Our Ref: A/14/10/L

Application for listed building consent for replacement of existing dilapidated clay tiles to roof with reclaimed clay tiles on new battens. Provision of wrought iron grilles to 4 no. roadside window openings

Outbuilding (former stables) Updown Cottage Arundel Road Angmering

DRAWING TITLE
PROPOSED ELEVATION TO
ARUNDEL ROAD

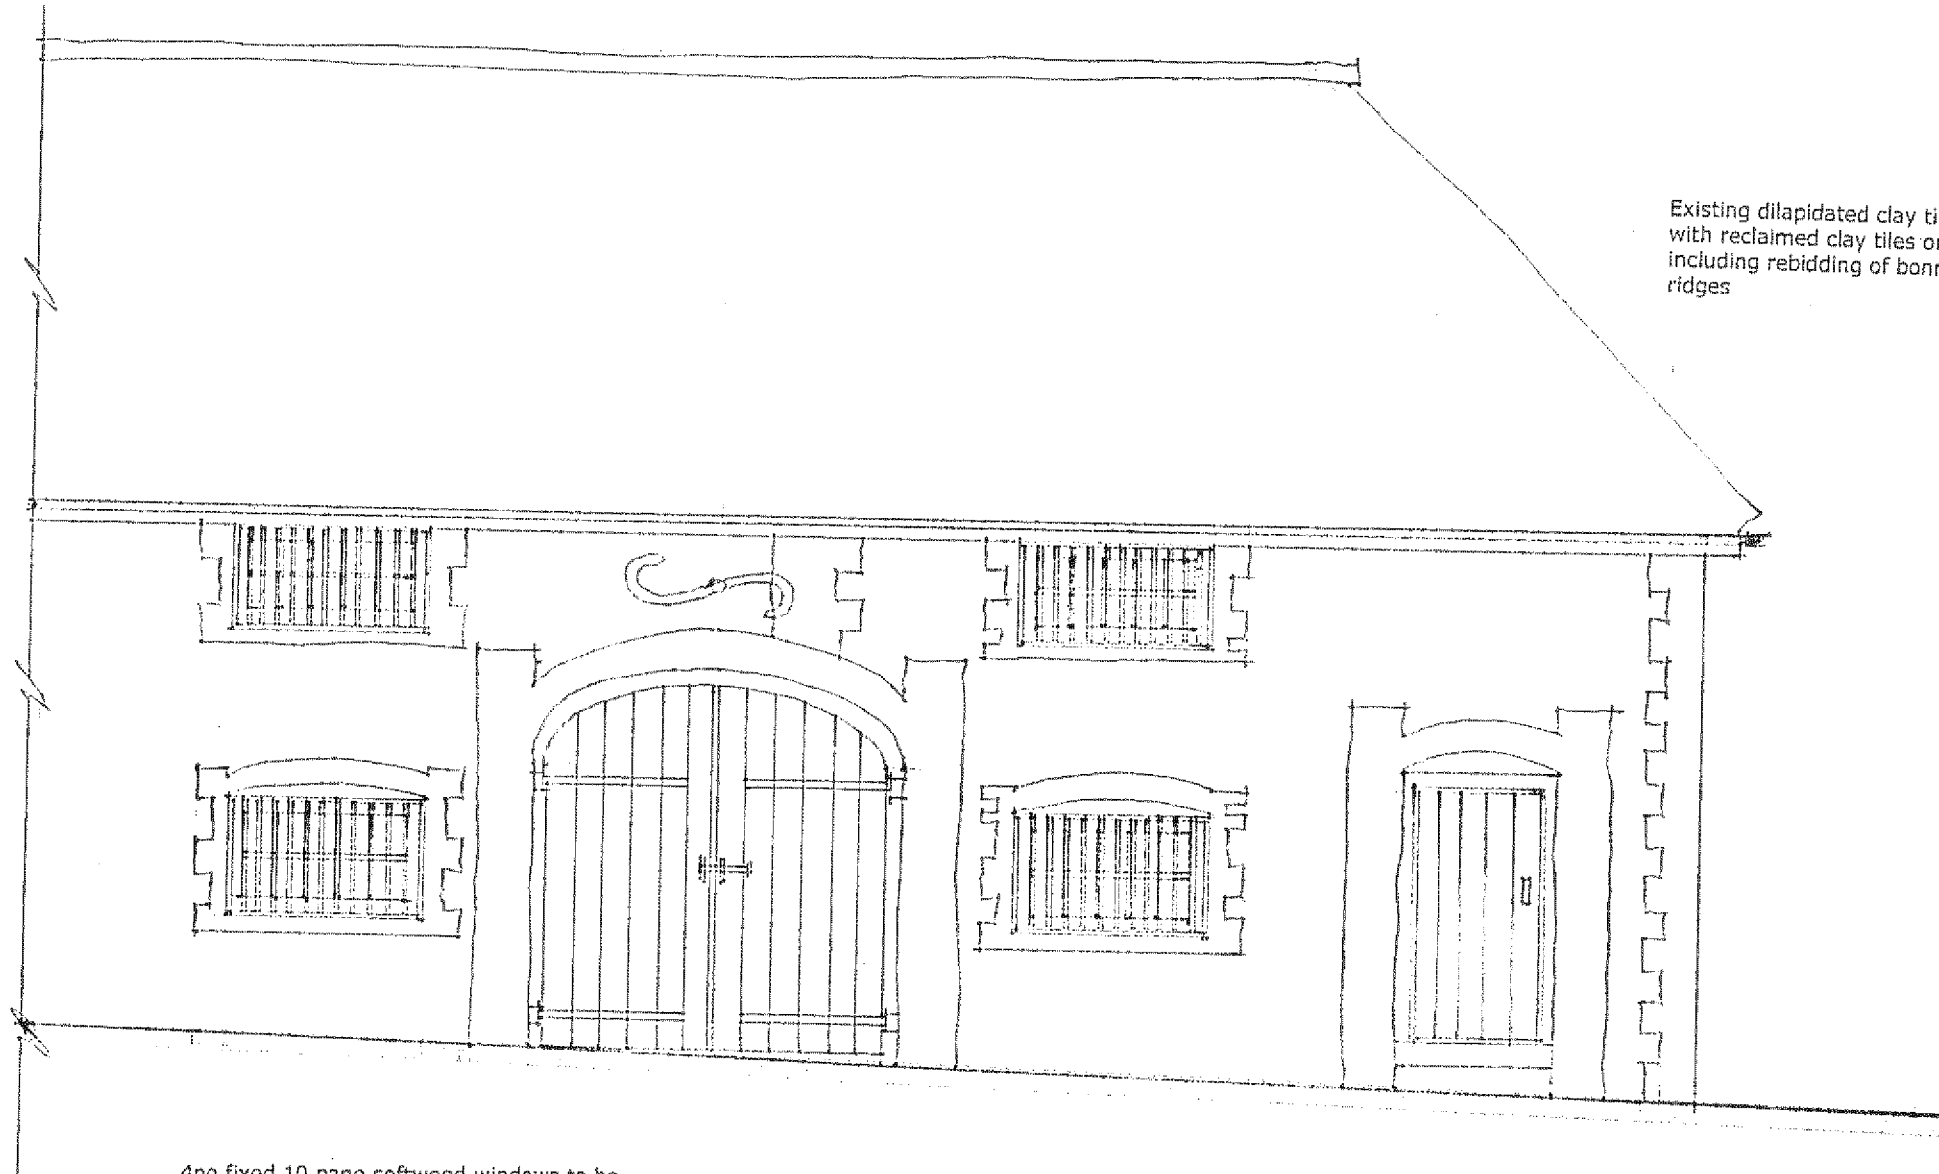
Objection. No objection to the part of the application relating to the replacement of the roof tiles. Objection to the provision of the four metal grilles as this property is in a Conservation Area and the external appearance of the property will be adversely affected.
